May 13, 2022

Re: PA22-015 - Colvin PRD – Technical Review 1

After preliminary review of the above referenced proposal, the Planning Division has the following comments:

MAINVUE WA, LLC
 1110 112TH AVE NE, STE 202
 BELLEVUE, WA 98004

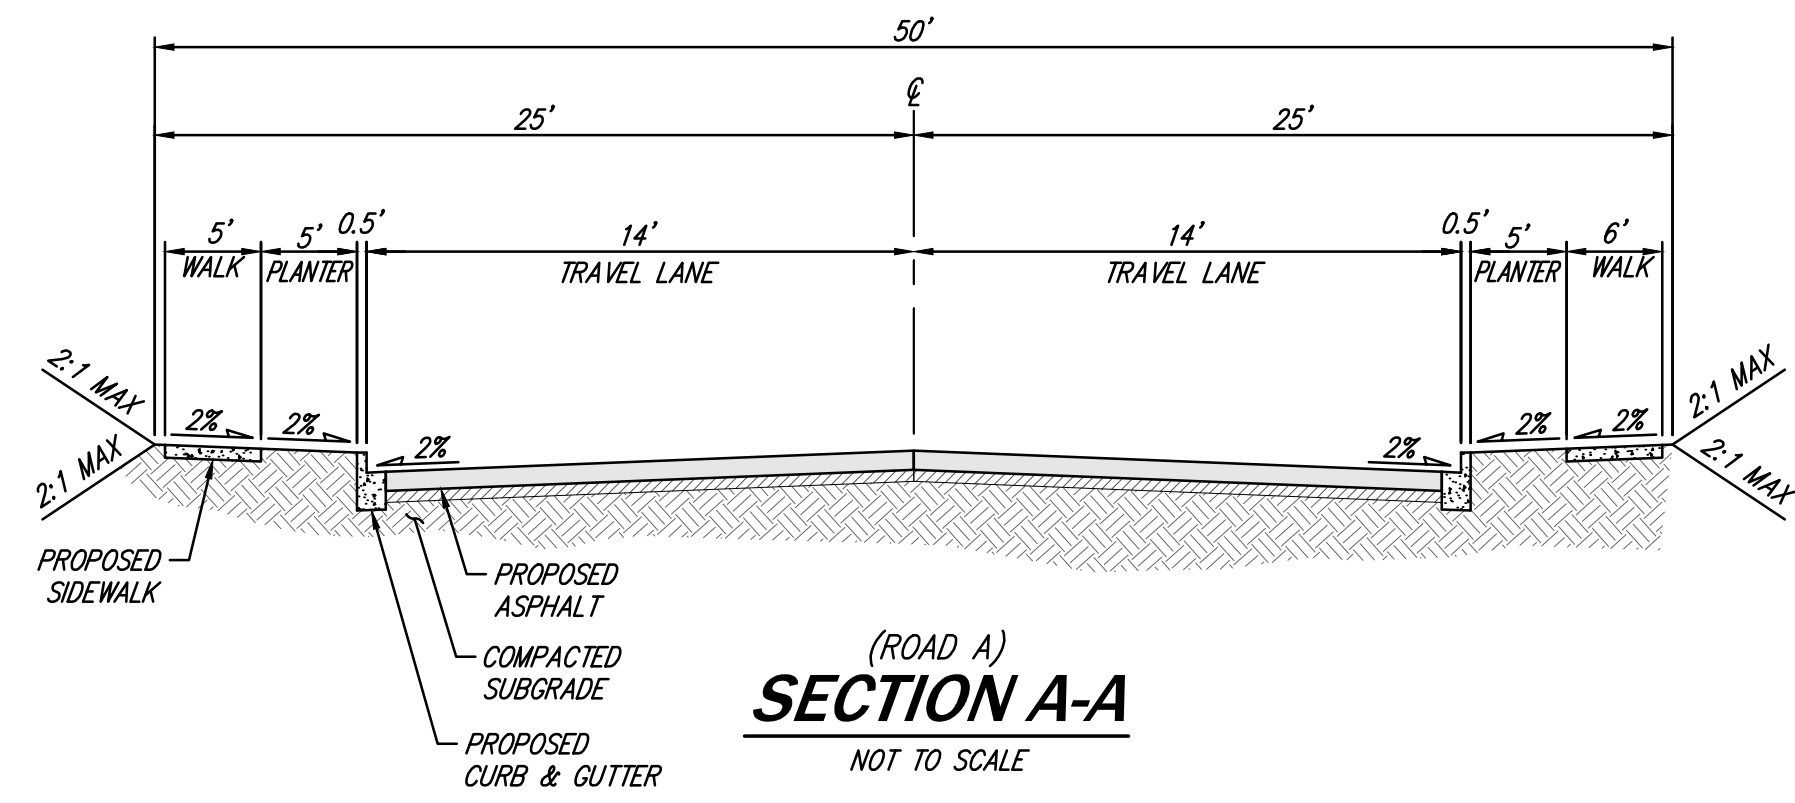
3. Based on review of **Sheet C4.01**, there appears to be multiple retaining walls exceeding the allowable 4 ft. threshold, which requires wall terracing. Please clarify how compliance with MMC 22D.050.030(4) is to be satisfied for the proposed retaining walls exceeding 4 ft. in height.

3.1. Please revise to add the top and the base elevations for all retaining walls as well as off-site topography to determine any impacts to adjacent properties due the wall massing.

LANDSCAPE PLAN

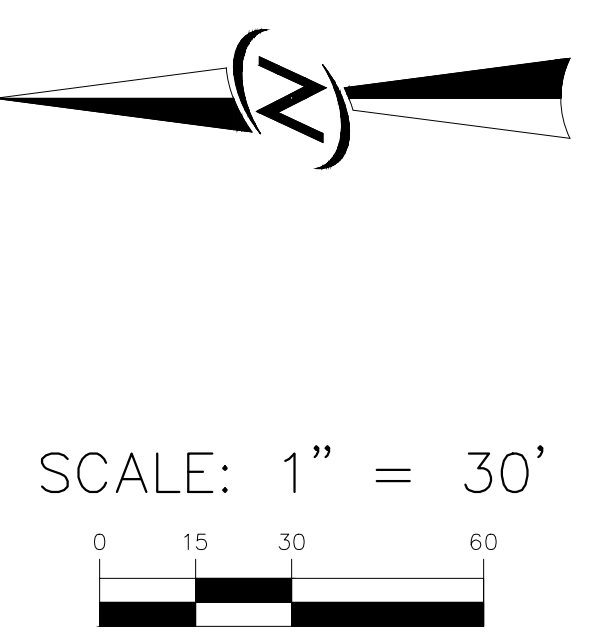
4. Based on the application materials, RDI 7b per MMC 22C.090.030 is proposed. The landscaping plan on **Sheet L2.01** is not clear as to how “retention or creation of a perimeter buffer” is proposed as a 6 ft. perimeter fence is shown.

Please provide a detailed depiction of the proposed 5 ft. compatibility perimeter buffer, including all vegetation to be retained.

9. To qualify for RDI bonus units under 6(a) & (b), qualifying active and passive recreation must be clearly demonstrated. Please provide clarification as to what areas in Tract B are to be considered passive versus active recreation; the demonstrations on L2.01 are not explicitly clear.

Please note, the areas of passive versus active recreation cannot be double counted; the recreation types must be clearly identified with the allocated square footages.
